**WEST SUSSEX COUNTY COUNCIL
INFRASTRUCTURE CONSULTATION**

SUBJECT: Y/58/10

34 Downview Close, Yapton

Outline application for new dwelling

G-820-01
MAY 2010

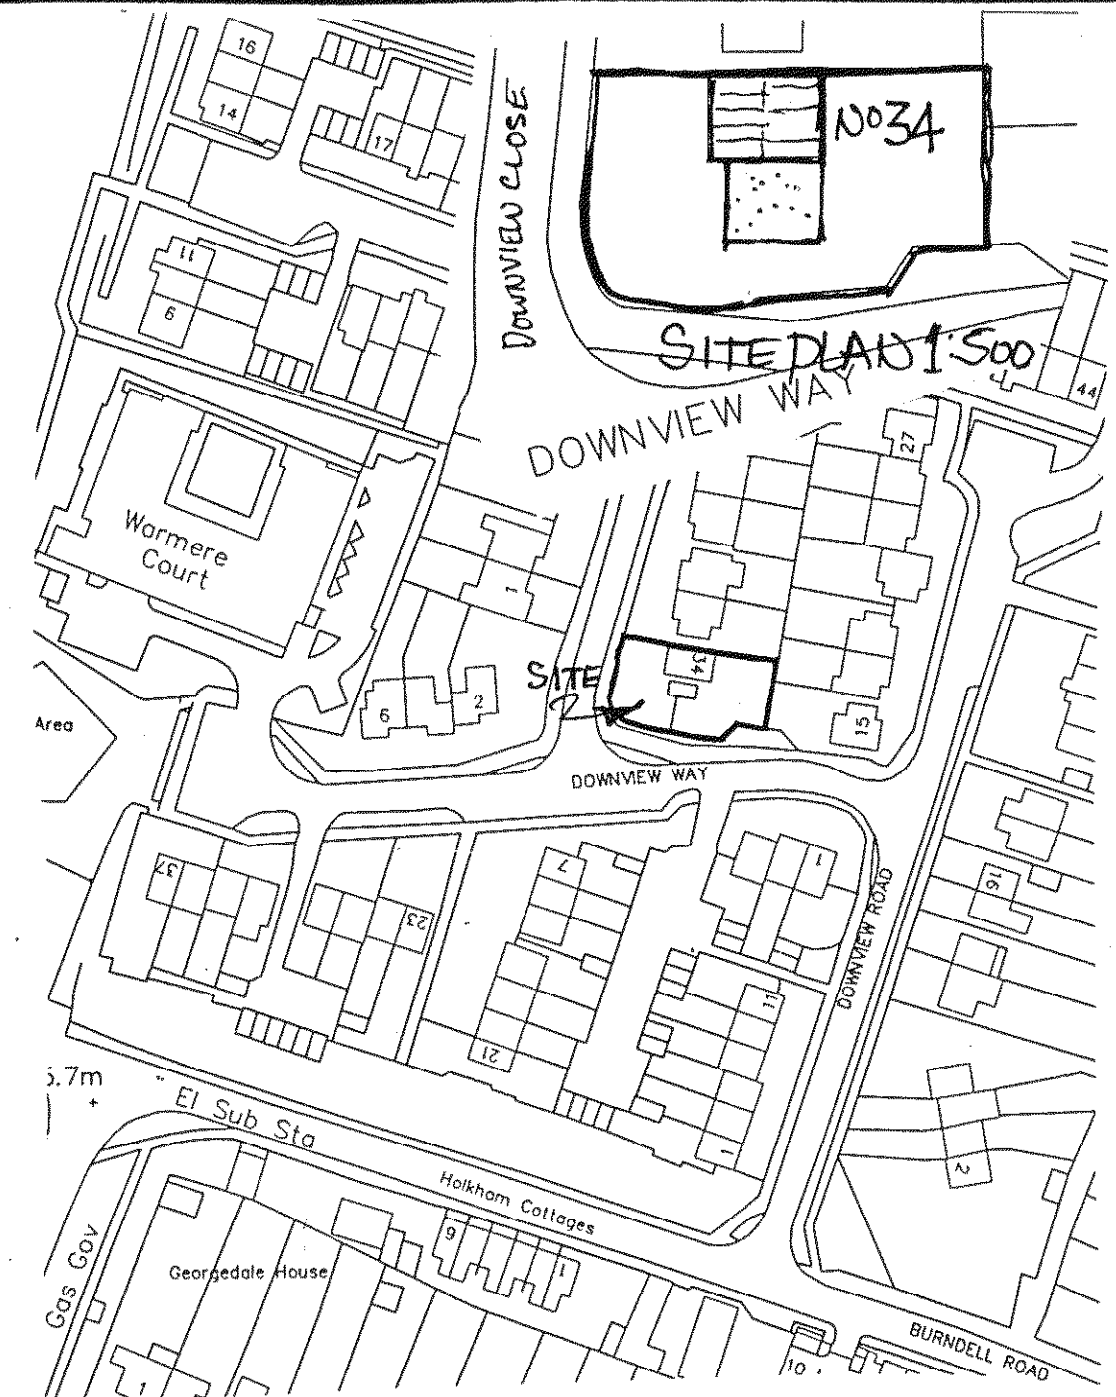
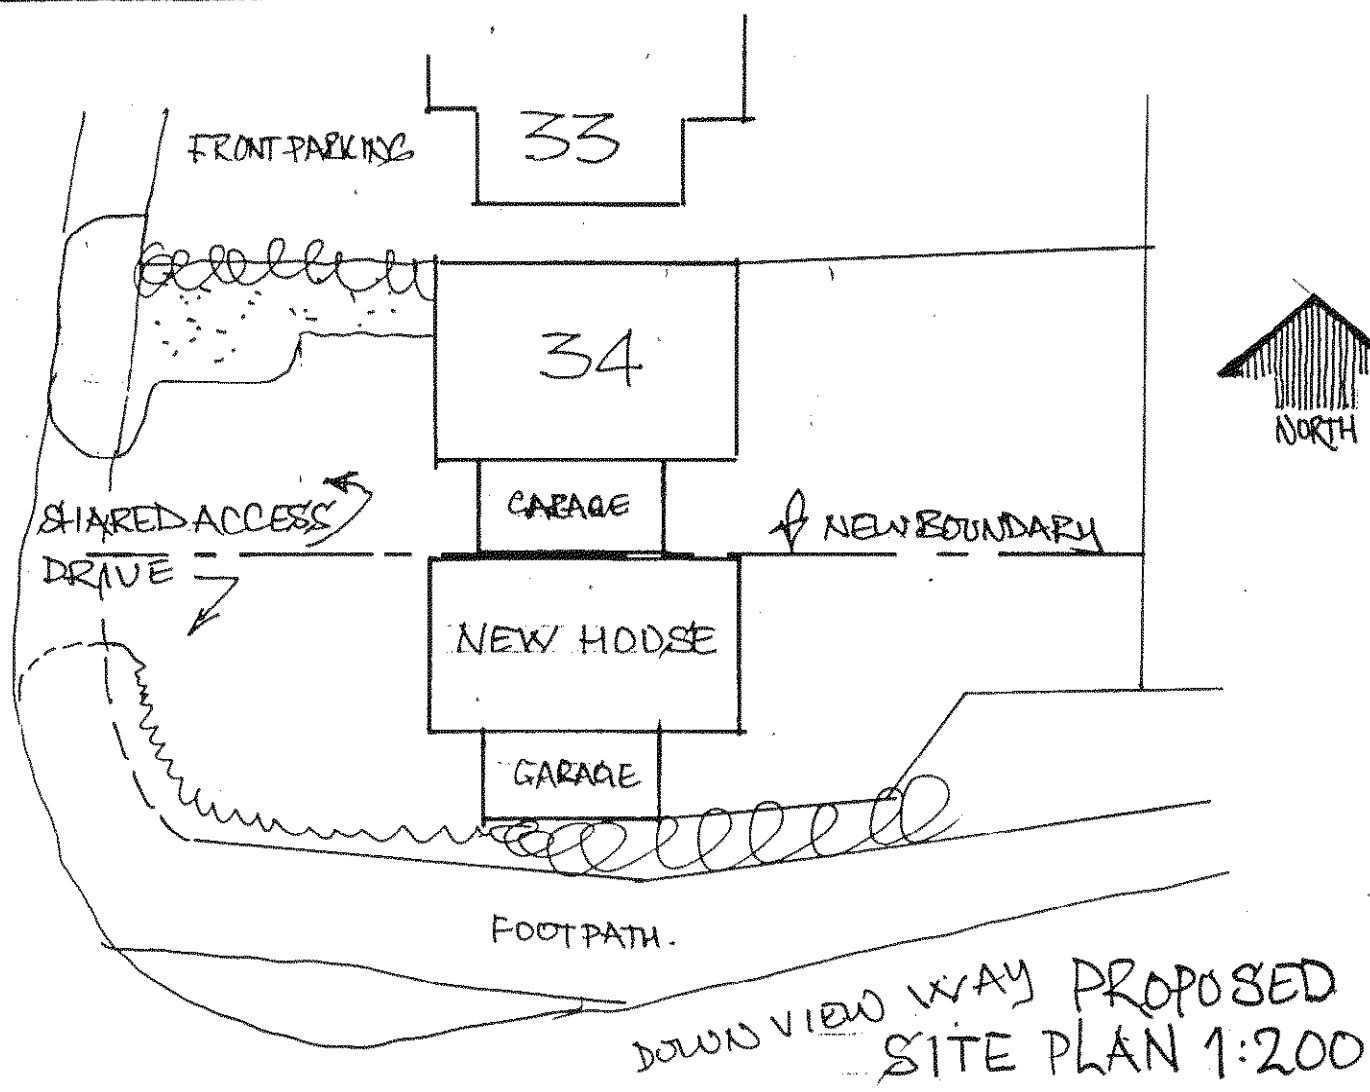
This outline application is for the erection of an additional dwelling using an existing shared access drive onto Downview Close. From an inspection of the plans alone there is no apparent visibility issue at the point of access, however pedestrian visibility should be secured by condition.

It would appear that the shared access is not wide enough to allow 2 vehicles to pass each other, and WSCC would therefore recommend that the access is widened to 4.5m to allow for this – and would also recommend that this be secured by condition. Furthermore, WSCC would recommend that a condition be attached to ensure that surface water does not discharge onto the publicly maintainable highway.

The application also proposes 3 parking spaces, which would seem excessive for this development. However, WSCC does not anticipate that the provision of these spaces would have a negative impact on highway safety in this location.

No archaeological implications - the proposed dwelling appears to be sited on top of an infilled section of the former Portsmouth and Arundel canal. The applicants may wish to explore this further with their agent/ builder as it may influence their choice of foundation design.
